Rezoning Transportation Analysis

Petition Number: #2022-051

Transportation Summary

CONCEPT PLAN - SF ATTACHED

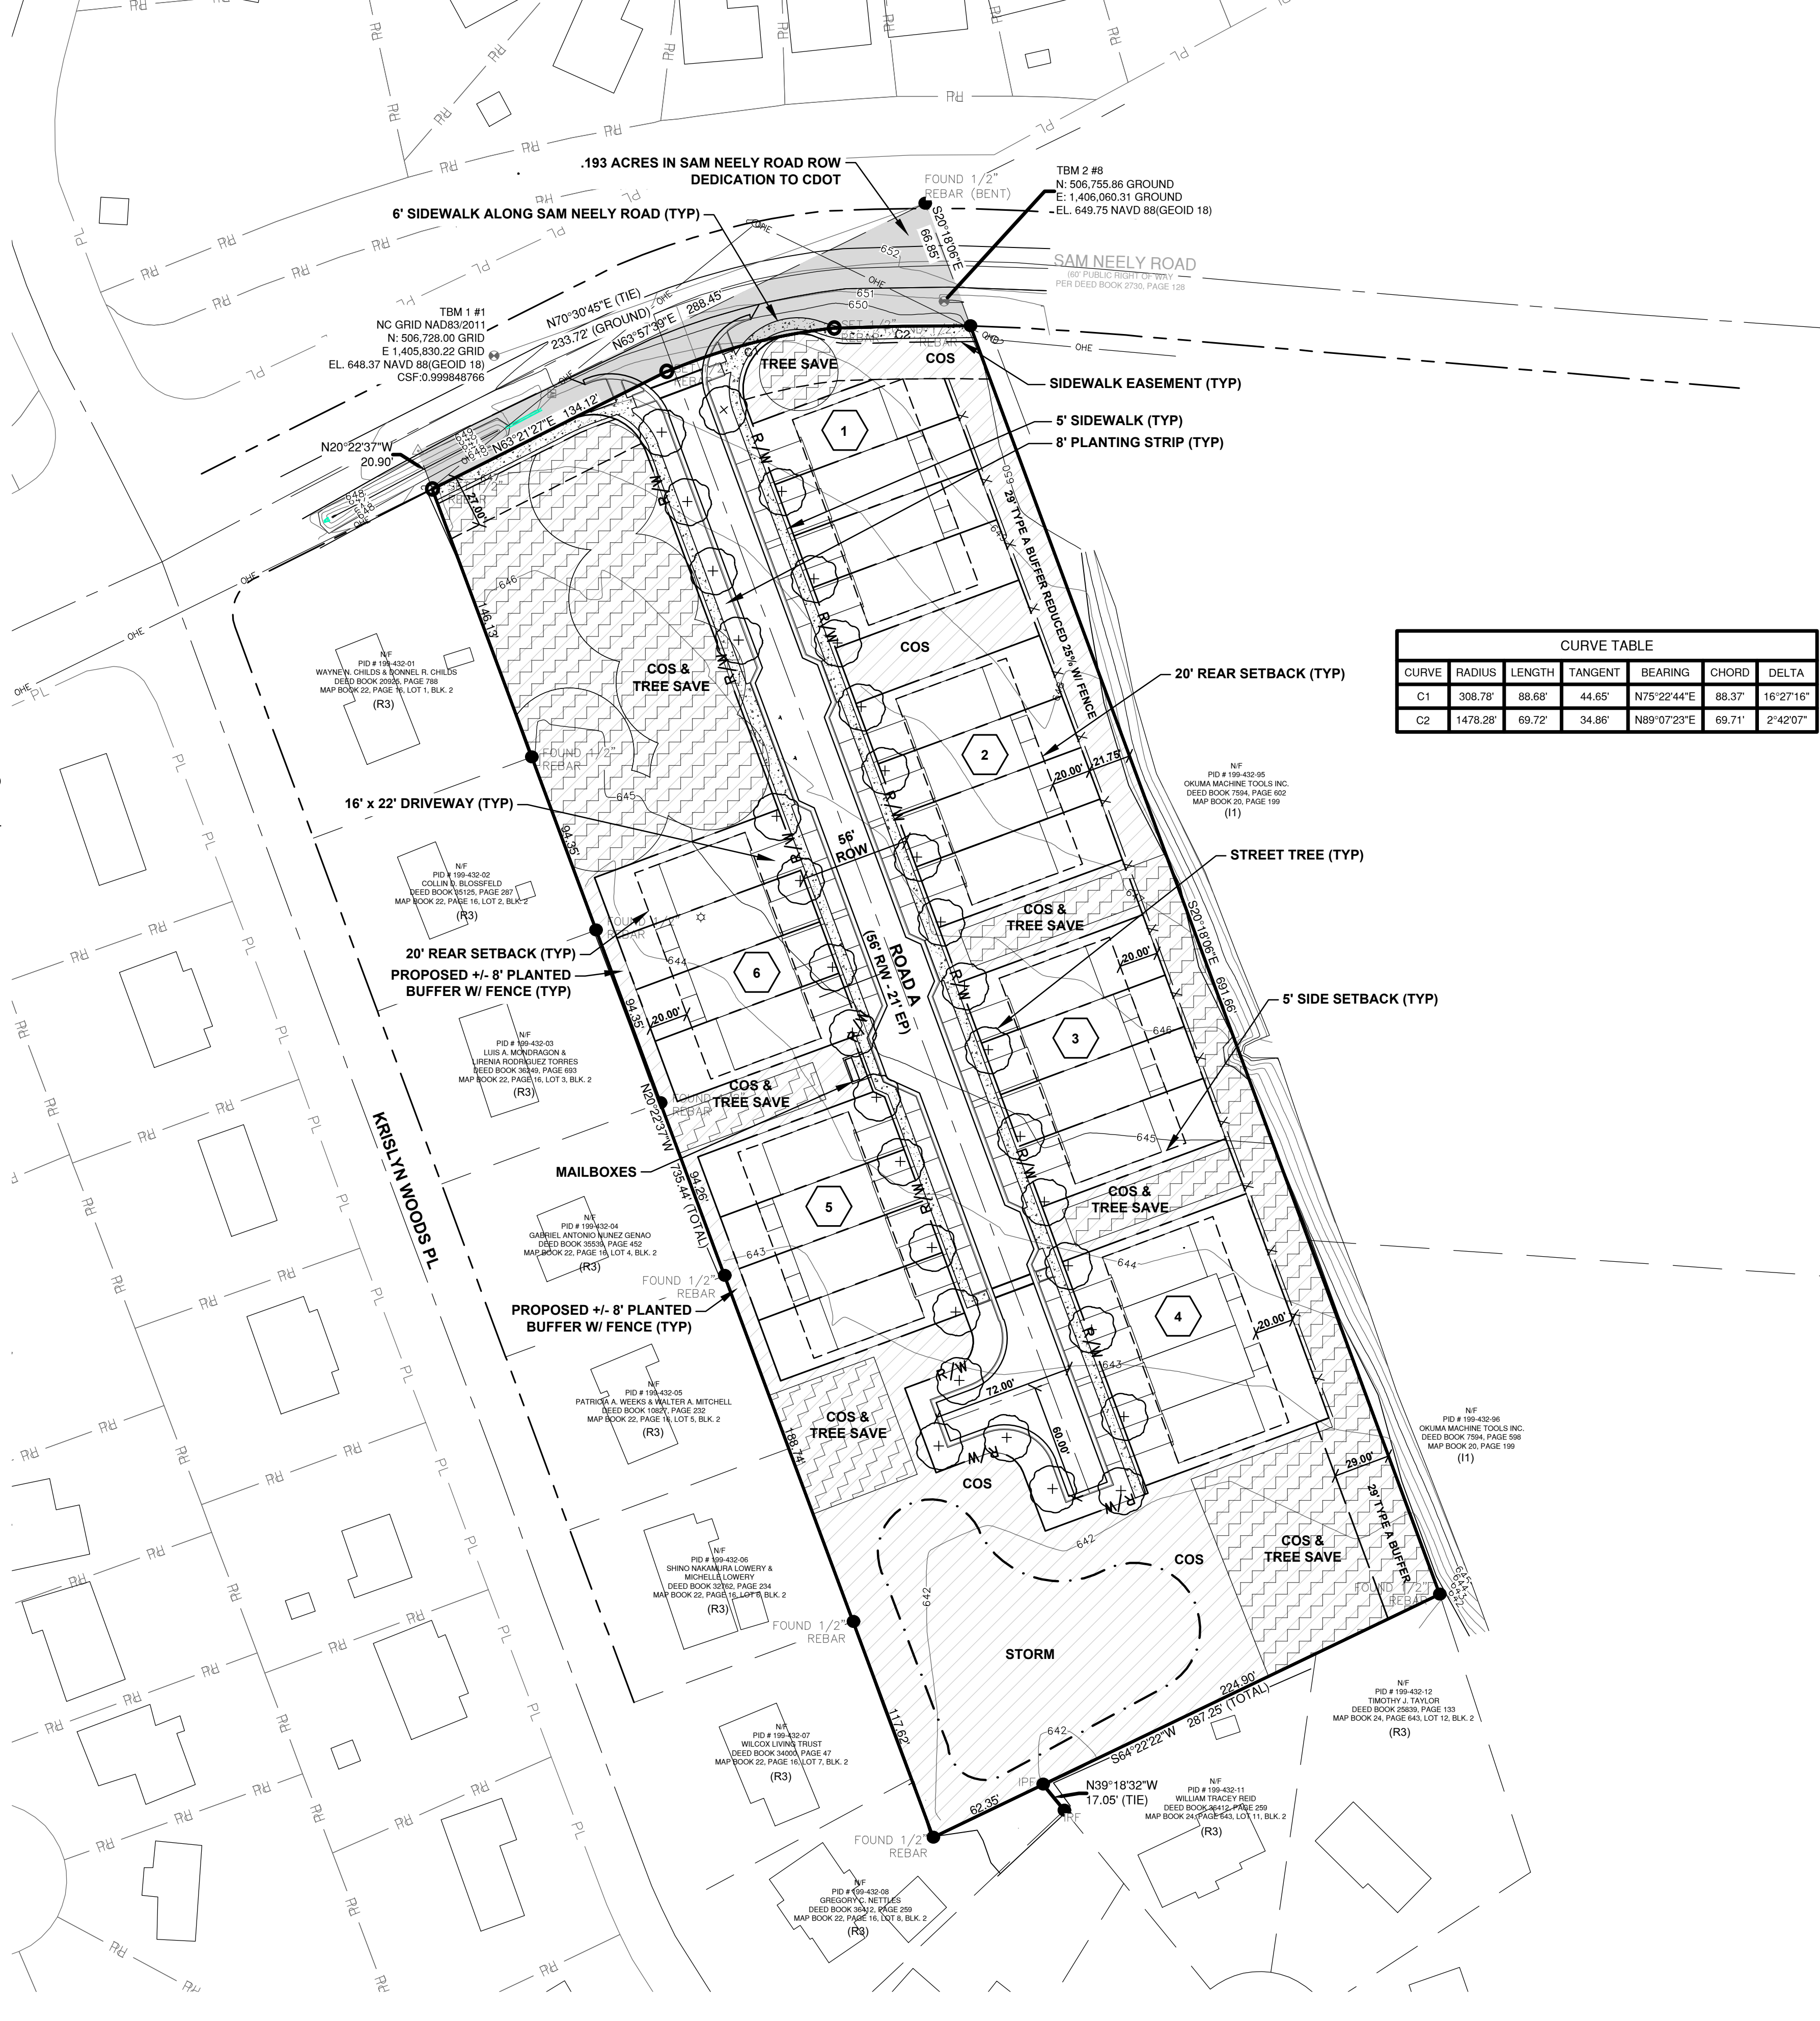
- ~~1. Revise the site plan and conditional notes by committing to construct curb and gutter, along the site's frontage of Sam Neely Road, measured 19 feet from the existing centerline to back of curb.~~

~~Label and dimension the back of curb from the existing centerline of Sam Neely Road.~~

- ~~3. Revise site plan and conditional note(s) to commit to dedicate 43 feet of right of way along the site's frontage of Sam Neely Road.~~

~~The site plan shall label and dimension the right of way from the road centerline.~~

- ~~4. Revise site plan and conditional note(s) to commit to construct an 8-foot planting strip, and 12-foot shared-use path along the site's frontage of Sam Neely Road. The site plan shall label and dimension both items from the back of curb and gutter.~~

- ~~5. Revise the site plan and conditional notes to commit to construct proposed Public Road A in accordance with CLDSM U-02, local residential medium street.~~

- ~~6. Revise the site plan by removing the proposed crosswalk markings, across Public Street A, and extending the sidewalk around the hammerhead.~~
